Technical Advisory Note

Project	Uniting Charlestown Modification 2	Project Number	SCT_00575
Client	TSA Management on behalf of Uniting		
Document Name	Traffic statement for Modification 2		
Version	2.0	Date	24 March 2026
Author	Shawn Cen	Principal Consultant	
Reviewer	Jonathan Busch	Director	
Authoriser	Jonathan Busch	Director

- PLA-CT-MP-DWG-AR-P4-00101 [A] FLOOR PLAN - LOWER GROUND

Figure 13: Originally Approved, DA MOD 1 and Proposed Lower Ground (LG) of Building A (2 of 2)

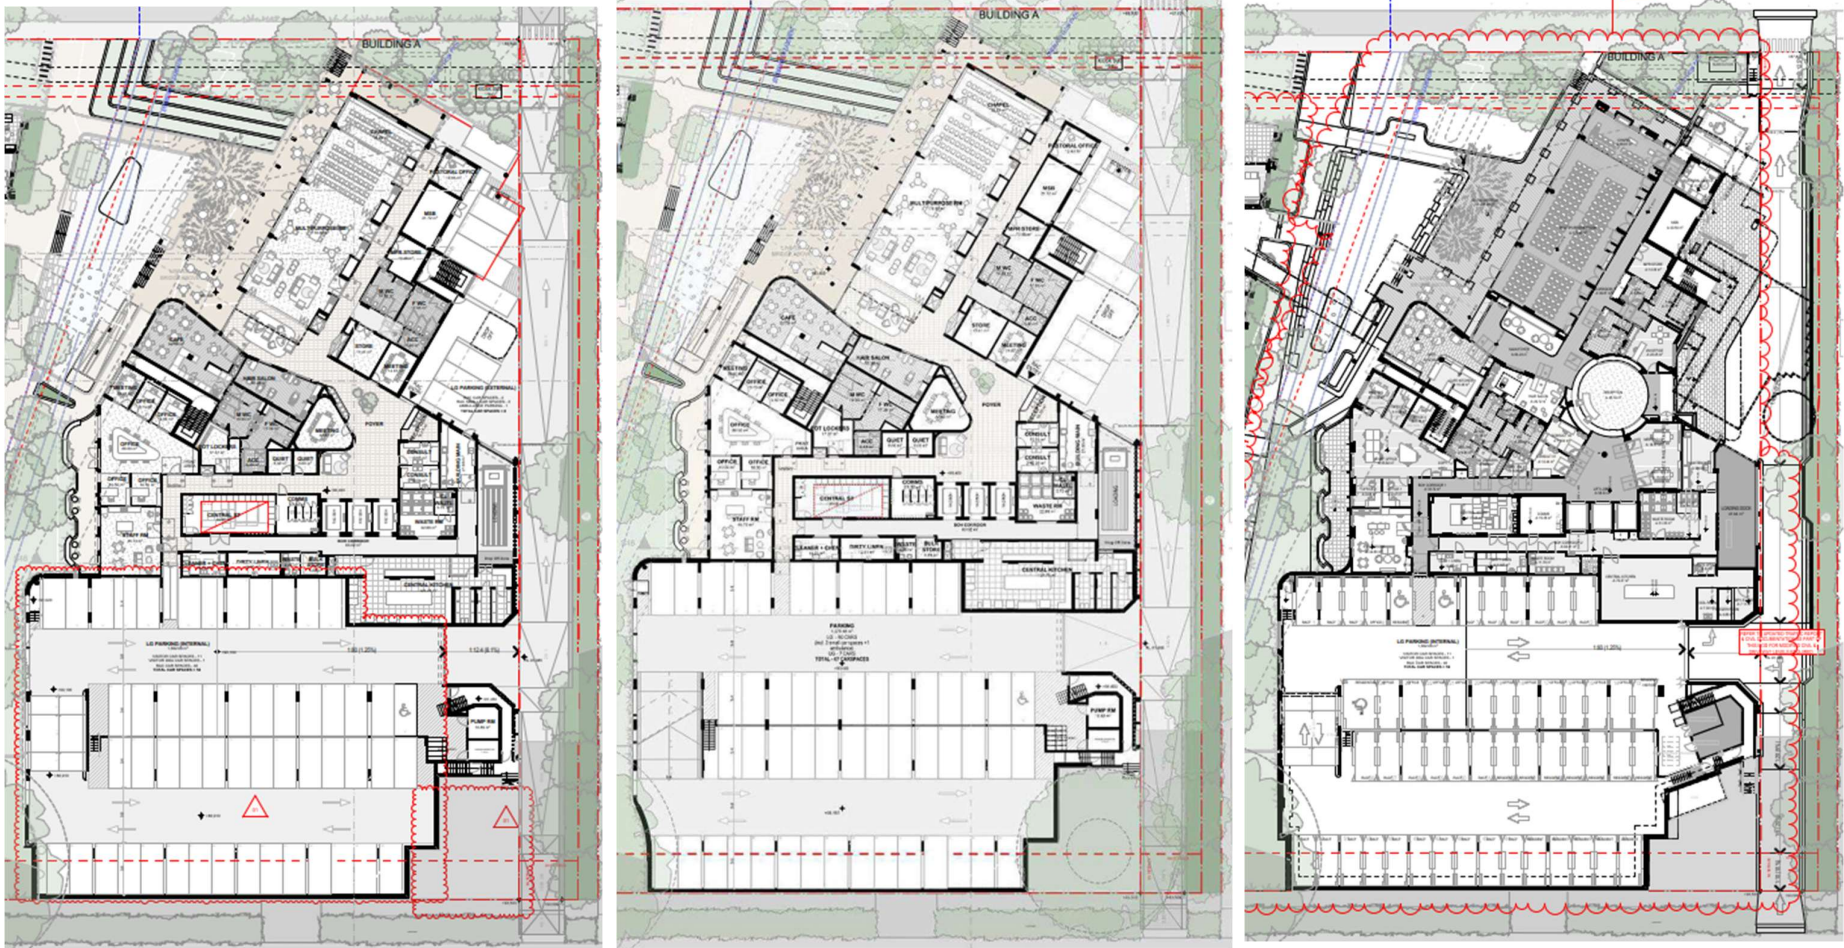
2.4.5 Physical controls	TBC	The distance from the front of the parking space to the wheel stop at the point of contact to be 620 mm to 630 mm. This matter can be addressed in the detailed design.

2.3.3 Rear of vehicle	TBC	Accessible parking spaces are supplied with sufficient rear shared areas within parking aisles as required. Parking aisles are to have a posted speed limit no greater than 10 km/hr, as can be addressed at subsequent stages.

2.4 Zone for bollard, post and columns	TBC	Shared spaces to the side of accessible parking spaces are to be supplied with a bollard, post, or column of minimum 1300 mm height as required. This matter can be addressed in detailed design.
		Luminance contrast not included in this review as this falls outside the expertise of traffic engineering.

2.5.2 Parallel parking spaces	N/A	No parallel parking spaces are provided within the car park.
2.6 Pavement slope and surface	TBC	Maximum gradient to be 1 in 40 (2.5%). This matter can be addressed in detailed design.
		Type of seal and slip resistance not included in this review as this falls outside the expertise of traffic engineering.

2.8 Kerb ramps	N/A	Kerb ramps are not provided or required.
3.1.1 Non residential space identification	TBC	Each accessible space shall be identified by means of a white symbol of access in accordance with AS 1428.1 between 800 mm and 1 000 mm high placed on a blue rectangle with no side more than 1 200 mm, and placed as a pavement marking in the centre of the space between 500 mm and 600 mm from its entry point. This matter can be addressed in detailed design.

3.1.2 Residential space identification	TBC	Residential accessible spaces are to be supplied with a bollard, post, or column in adjacent shared space. This matter can be addressed in detailed design.

3.2.1 Space delineation and shared marking		Not included in this review as this falls outside the expertise of traffic engineering.
3.2.2 Pavement markers for accessible spaces	TBC	Accessible parking spaces to be outlined with unbroken lines 80 mm to 100 mm on the long edge. This matter can be addressed in subsequent stages.

AS2890.6 section	Consistent	Comment
3.2.3 Pavement markers for shared areas	TBC	Shared areas to the side of accessible parking spaces are to be marked with unbroken lines 80 mm to 100 mm wide on all sides. Areas are also to be marked with diagonal stripes 150 mm to 200 mm wide with spaces 200 mm to 300 mm between stripes. Stripes are to be at an angle of 45 degrees to the side of the space.
3.2.4 Pavement markings		Not included in this review as this falls outside the expertise of traffic engineering.
